KITTITAS COUNTY DEPARTMENT OF PUBLIC WORKS

MEMORANDUM

SUBJECT: Mitchell Short Plat SP-17-00007

NANEUM ROAD SHORT PLAT

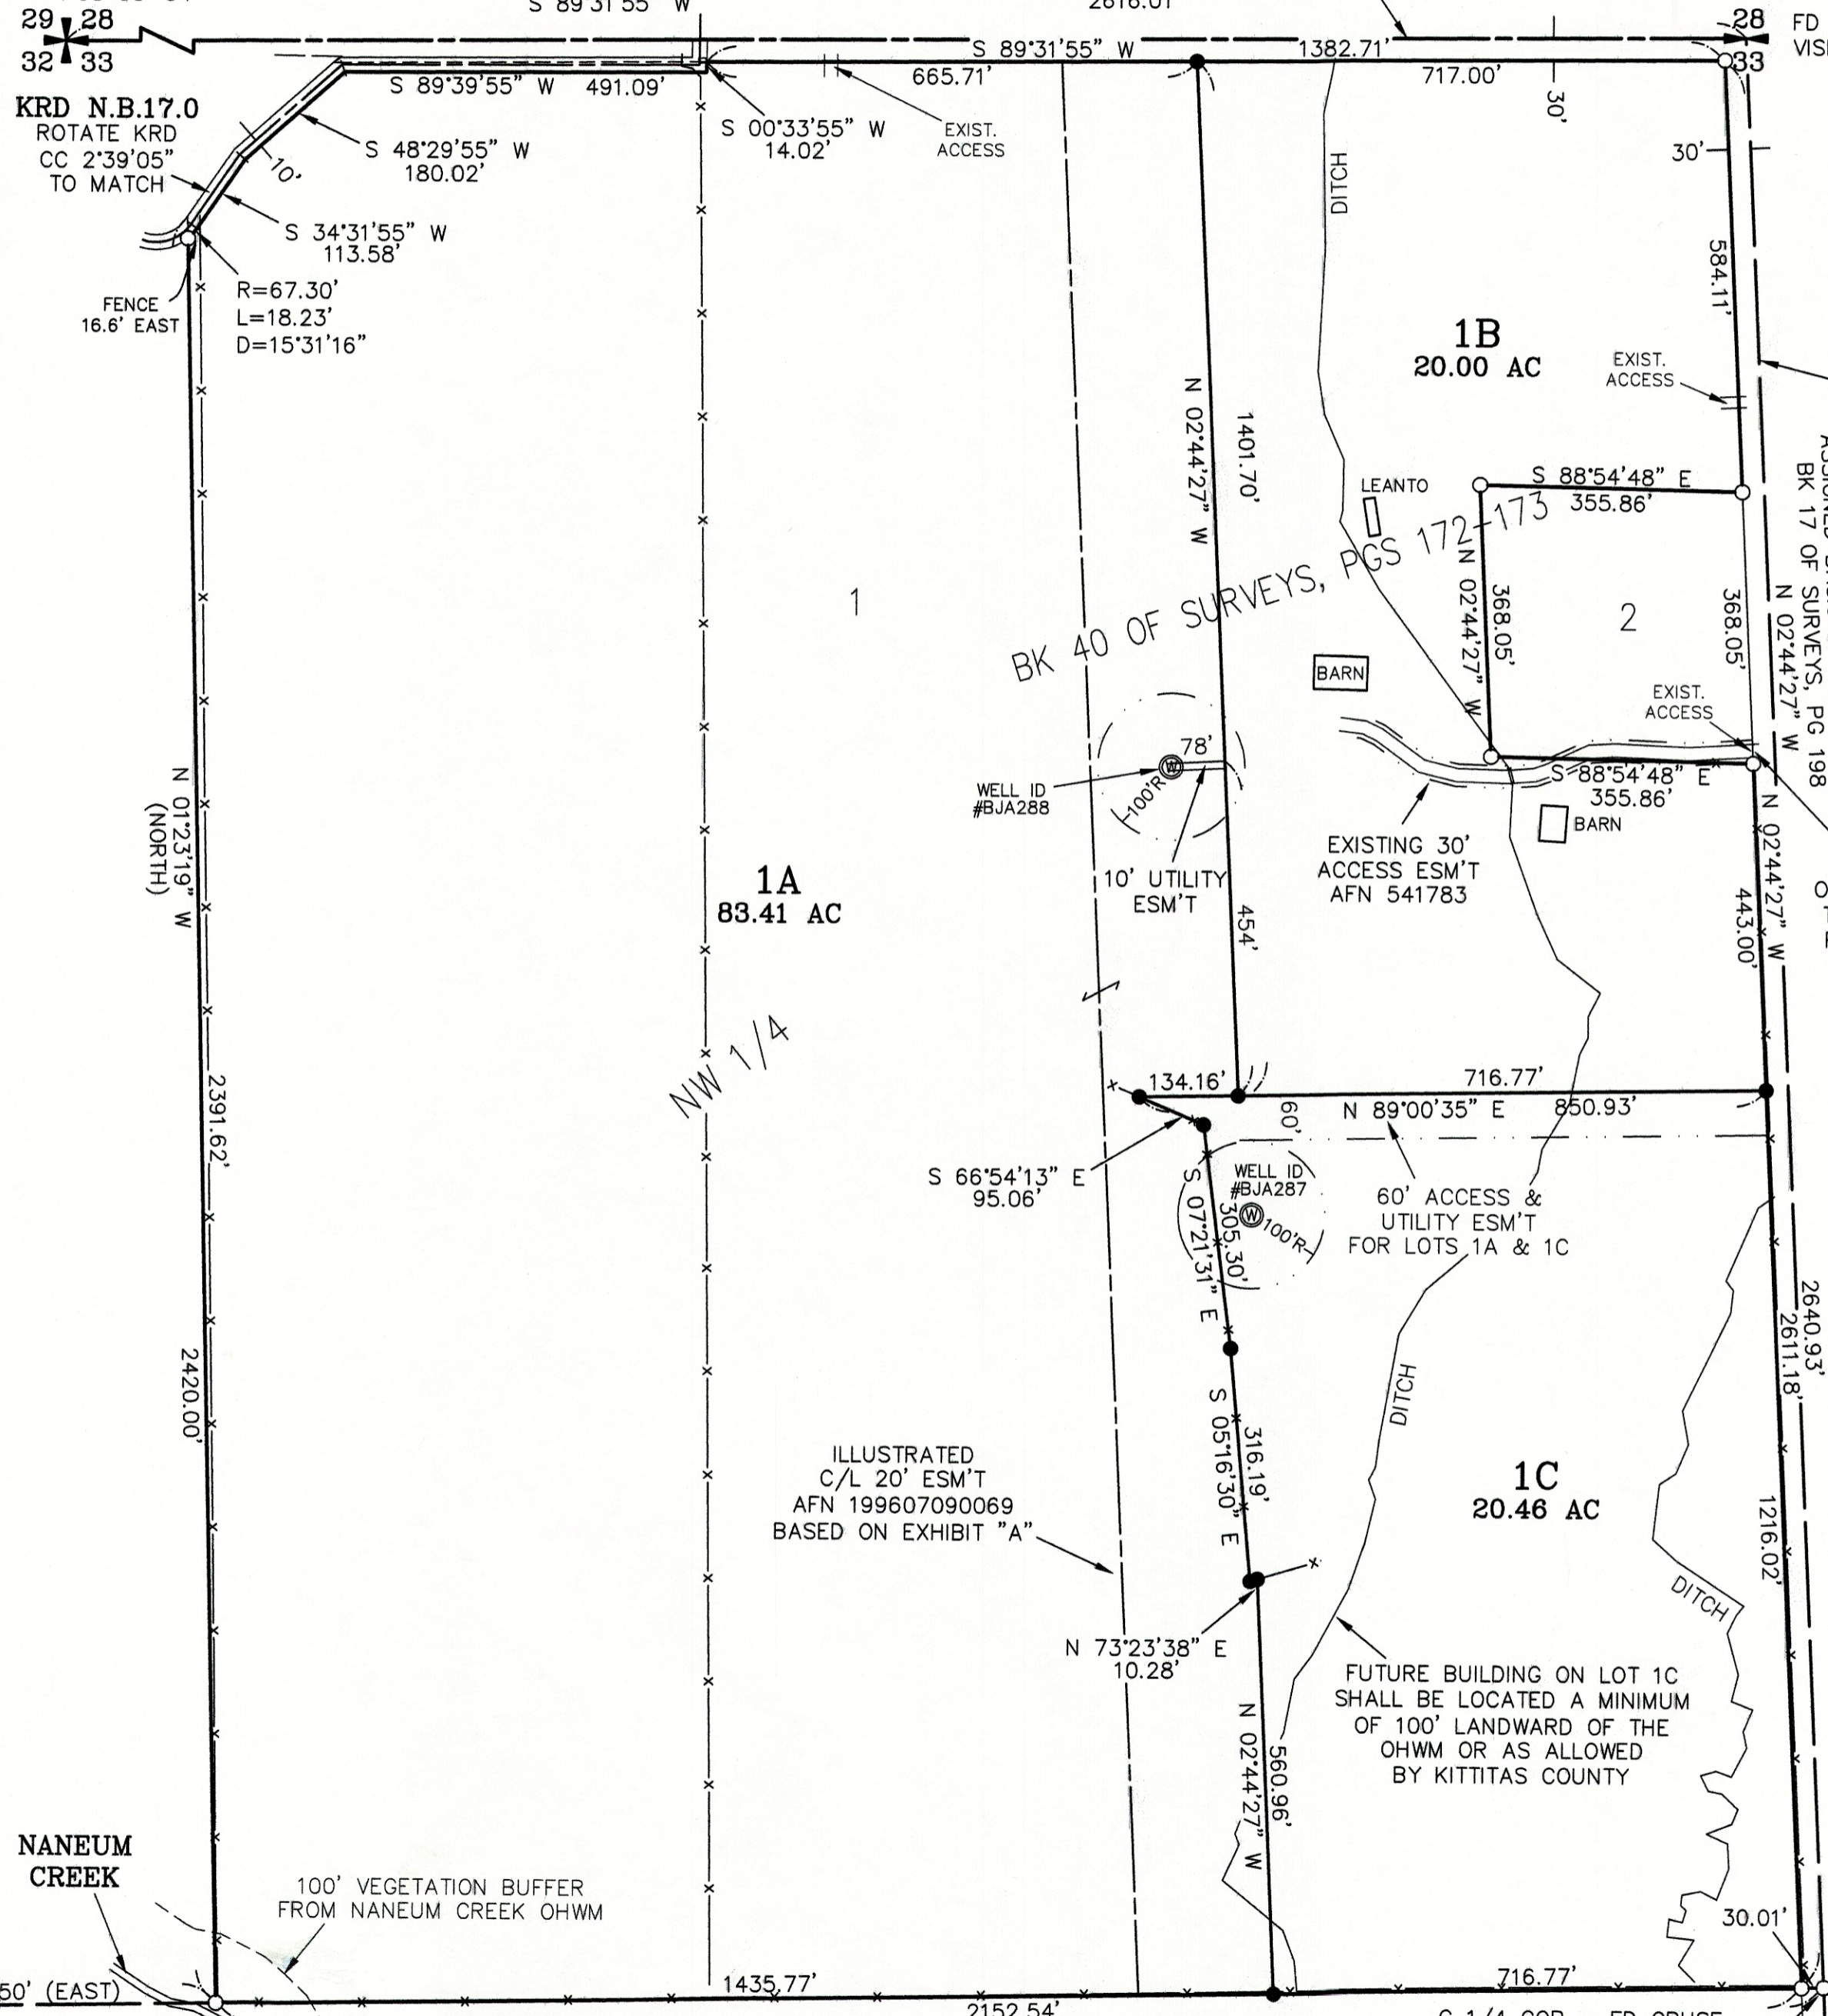
1. Lot 1A - Existing Access: The northerly existing access onto Game Farm Road to lot 1A needs to be labeled as "Existing Agricultural Access".
2. Lot 1B – Existing Access: The northerly existing access to lot 1B, north of lot 2, needs to be labeled as "Existing Agricultural Access".

3. Lot 2 and 1B: The existing access at Lot 2 with a 30' existing access easement shall be brought to joint-use driveway standards.
4. Lot 1C and 1A: The 60 foot access easement to lots 1C and 1A to be constructed to a joint-use driveway standard.
